Planning Application No: 3/2025/0967

Proposal: Proposed double garage, removal of garage doors and building up in stone, insertion of windows, sliding doors, roof lights and replacement windows and doors.

Location: Coulthurst Farm Old Vicarage Lane Talbot Bridge Bashall Eaves BB7 3DB

PROPOSED GARAGE PLAN

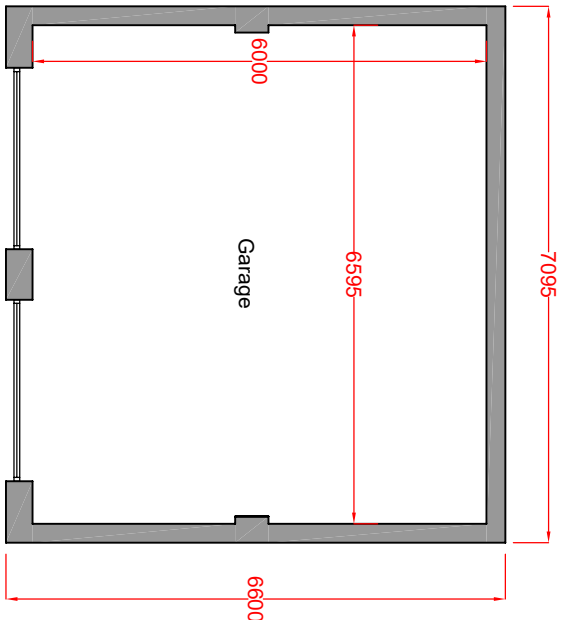
It is note that the proposed garage will replace the existing garage and provide storage for cycles (Ref. Planning statement, Highways and Parking 6.8),
There is no objection subject to the following condition.

- The garage(s)/parking areas hereby approved shall be kept available for the parking of vehicles ancillary to the enjoyment of the household(s) and shall not be used for any use that would preclude the ability of their use for the parking of private motor vehicles, whether or not permitted by the provisions of the Town and Country Planning (General Permitted Development) Order 2015 or any order amending or revoking and re-enacting that order.
Reason: To ensure that adequate parking provision is retained on site
